From: Thomas Callaway
Sent: 22 December 2014 16:41
To: Planning.Responses
Subject: RE: Planning Consultation on: FG/161/14/PL

NOTIFICATION FROM ARUN DISTRICT COUNCIL
Town & Country Planning Act 1990 (as amended)
Town and Country Planning (Development Management Procedure) (England) Order 2010 (as amended)
Planning Permission
APPLICATION **FG/161/14/PL**
NO:

Site Address: Onslow Caravan Park Onslow Drive Ferring BN12 5RX

Description of Works: Proposed demolition of three buildings and erection of replacement workshop and machinery store

Project Name and Address
Floor Plan & Elevations
New Storage Barn
Onslow Caravan Park
Ferring

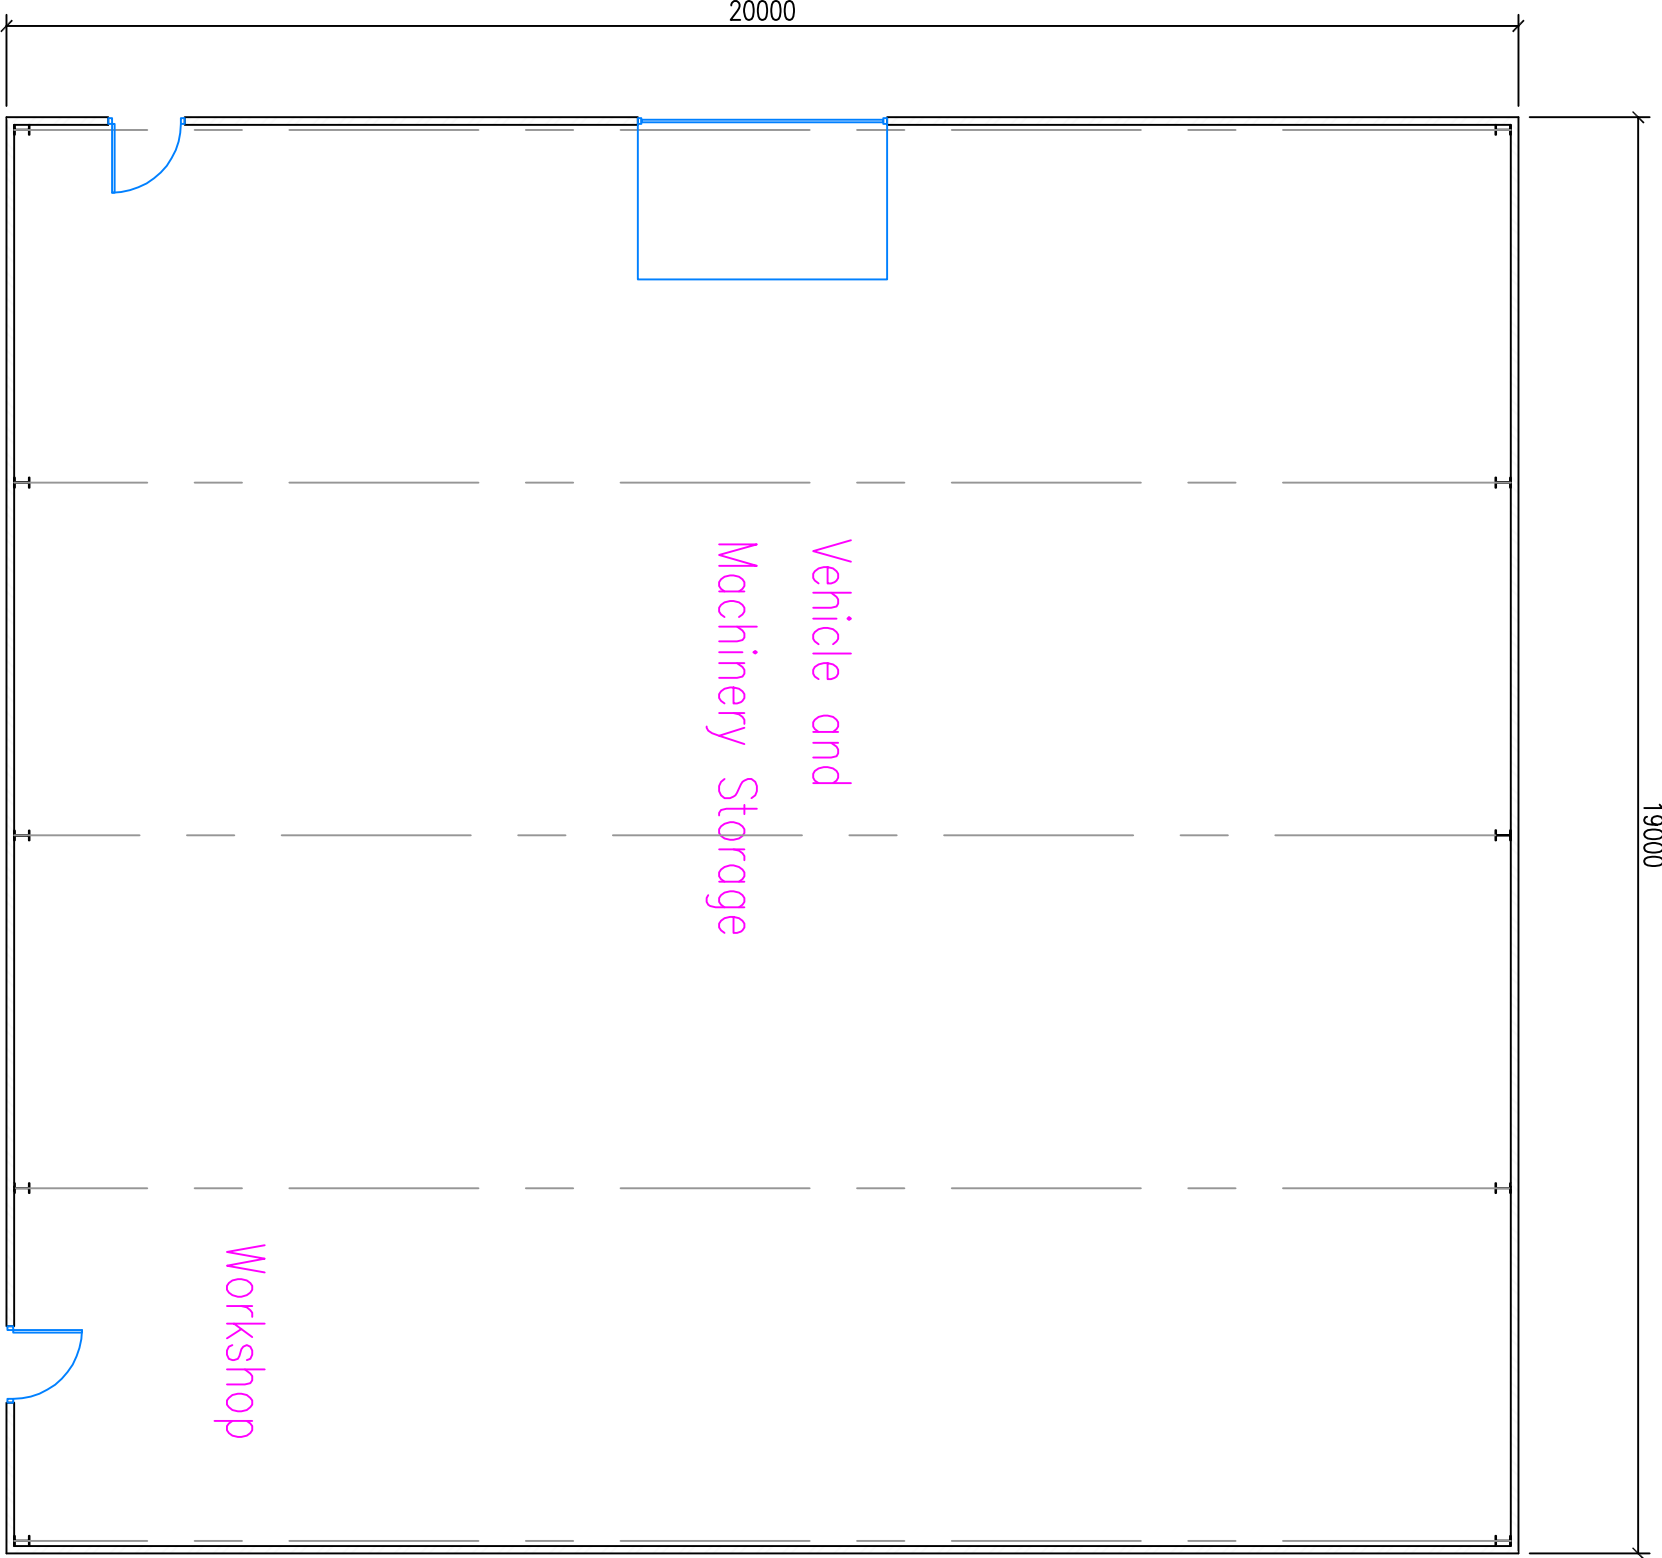
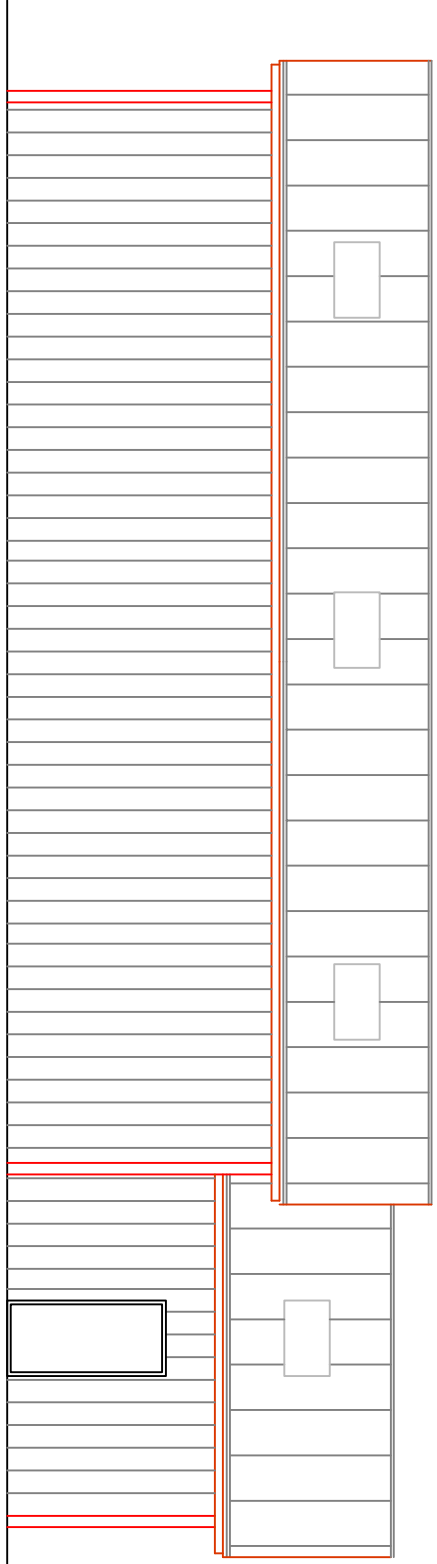
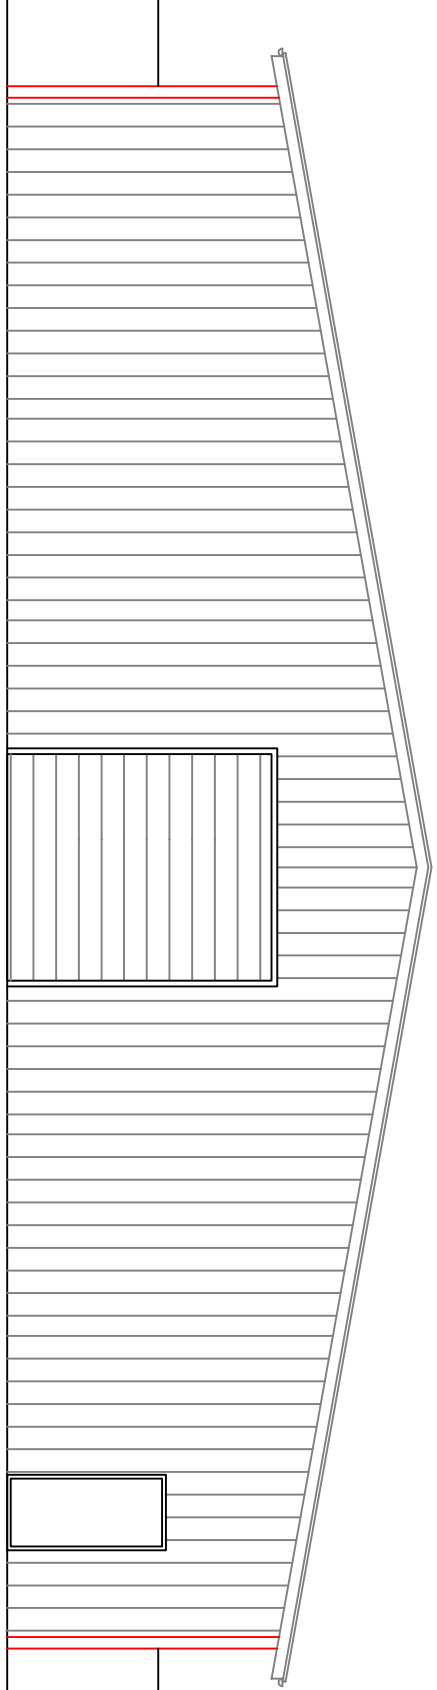
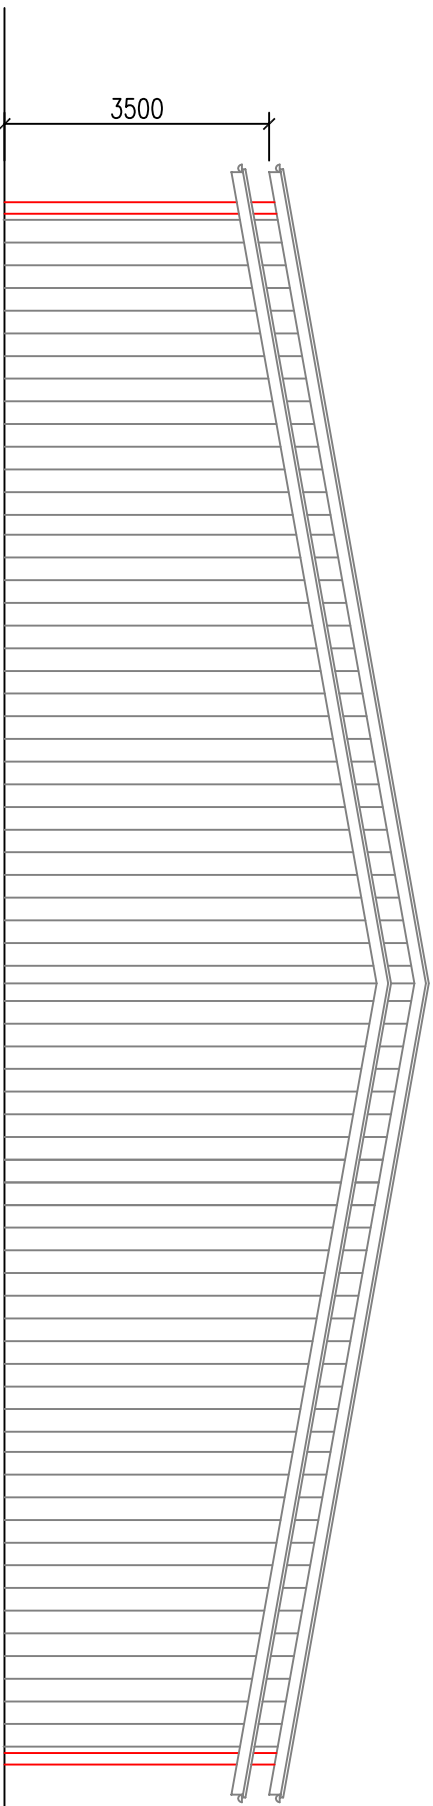
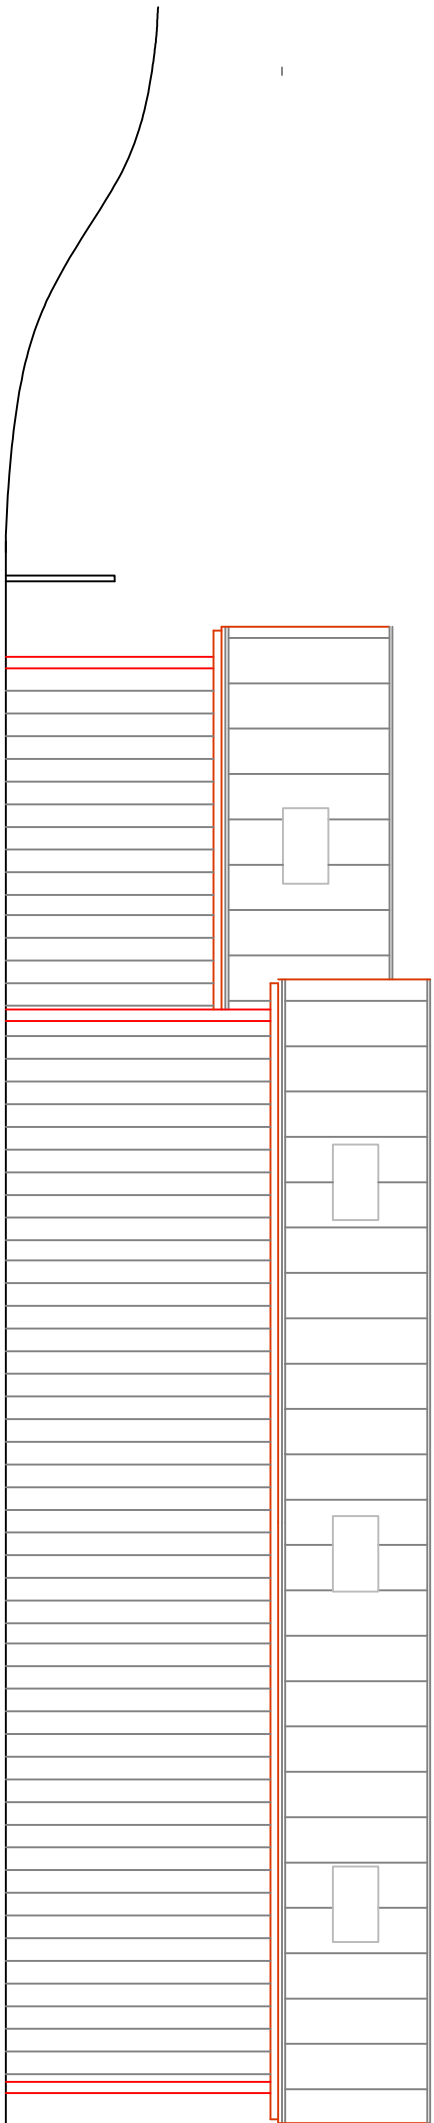
The building should not be constructed over the watercourse. We would ask for a minimum of a three metre easement between any proposed construction and the watercourse (including culverted watercourse), however as this is a main river, the EA may require an eight metre easement. Please consult the EA regarding this as it may require flood defence consent in addition to planning permission. Otherwise our position on easements should still stand and condition ENGD6A applied.
